**Dendrobium Mine Extension Project (SSI-33143123)
Advice on Environmental Impact Statement**

Attachment: EPA Submission re Dendrobium Mine Extension Project SSI-33143123

Review of surface water discharges for Dendrobium Mine extension EIS

Figure 25 – Night Scenario 1 Operational Noise Contours - $L_{Aeq, 15min}$, dB(A)

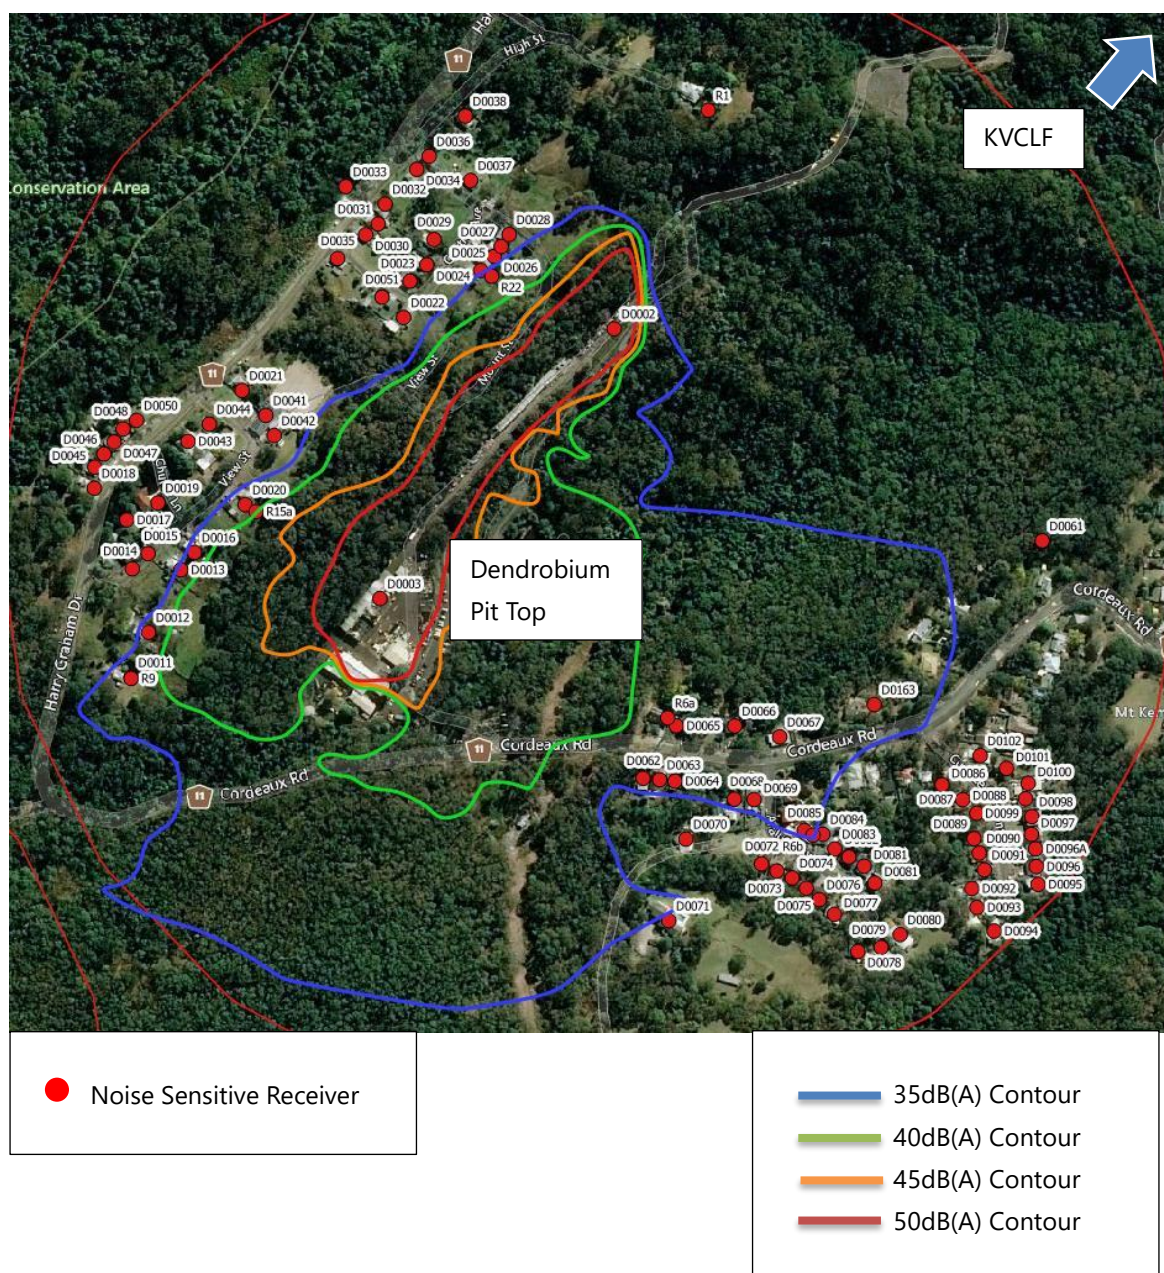
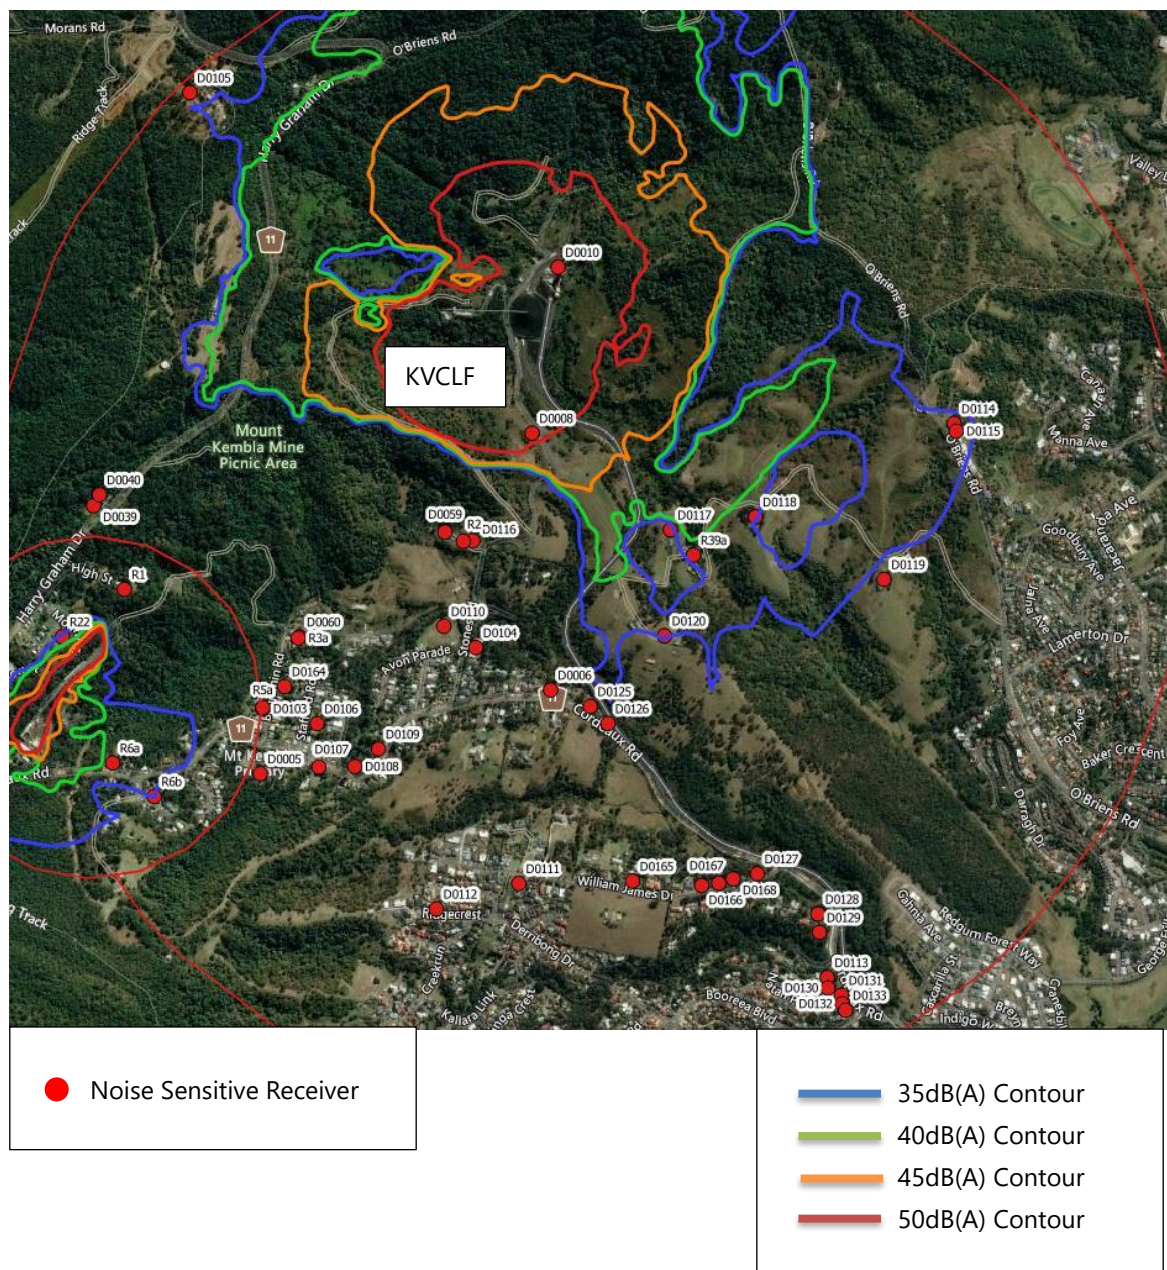
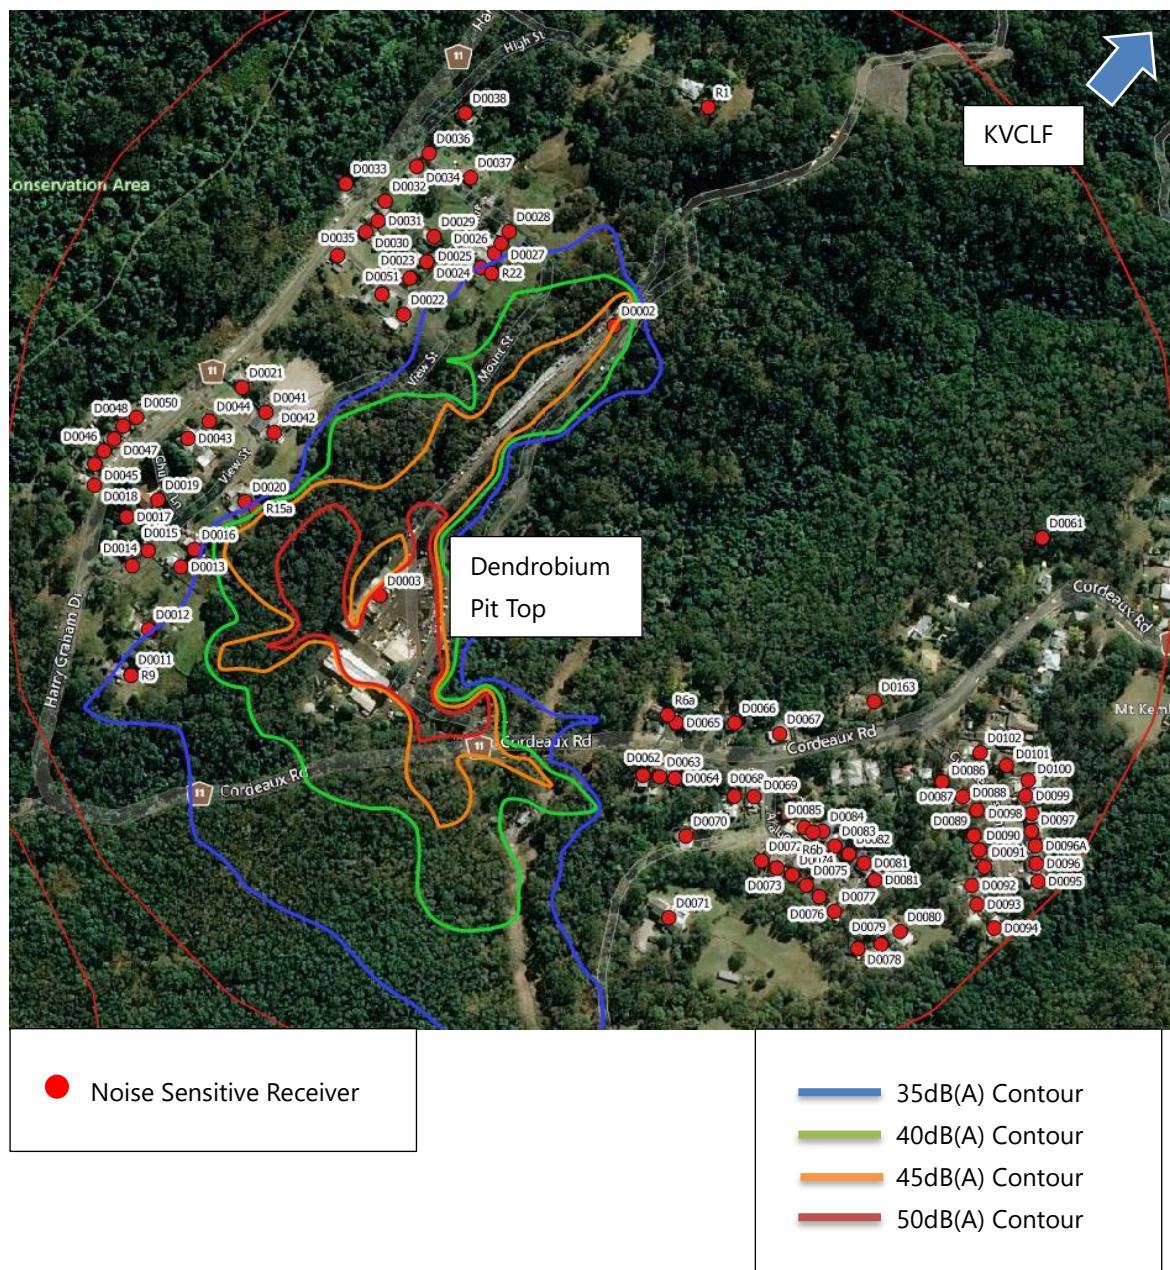
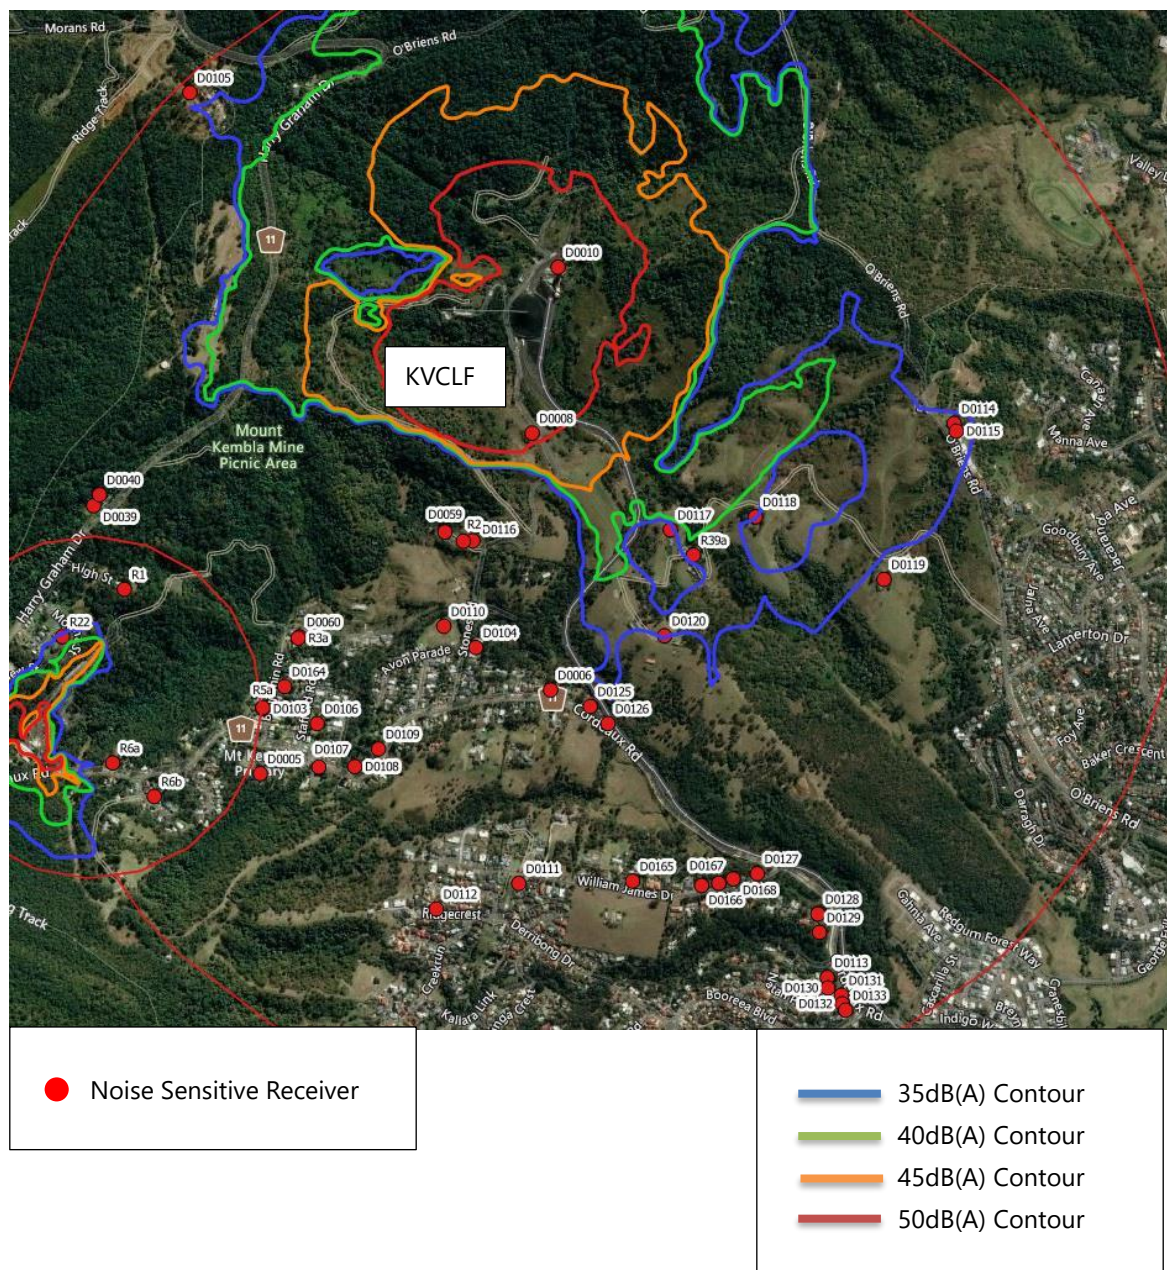
The highest predicted noise level for R39a in the noise report is 40 dBA at night, which is 5 dB above the Project Approval noise limits and equal to the Project Approval acquisition criteria. However, according to Chapter 3.4 of the EIS there are no significant changes proposed to the Kemira Valley Coal Loading Facility (KVCLF).

Therefore, it is unclear why the predicted noise levels are higher than the existing Project Approval limits where there are no significant changes occurring at the KVCLF.

- c) Receiver R6a is predicted to have noise levels more than 2 dB above the PNTL and 2 dB above the night-time recommended amenity level, which qualifies for the moderate mitigation category under the DPIE Voluntary Land Acquisition and Mitigation Policy 2018 (VLAMP). According to Table 1 of VLAMP, the receiver would be entitled to voluntary mitigation. The proponent has stated that the predicted night time noise levels are 5 dB above both the PNTL and the existing Project Approval limit.

- provide a justification for why the premises noise levels have increased at the receivers above the existing Project Approval noise limits without any apparent change of operations;
- provide a justification for why the existing Project Approval limits cannot be met; and
- review and confirm all reasonable and feasible mitigation has been applied to the project.

The noise report should clarify what commitment the proponent is making to investigate reasonable and feasible mitigation for receiver R6a.
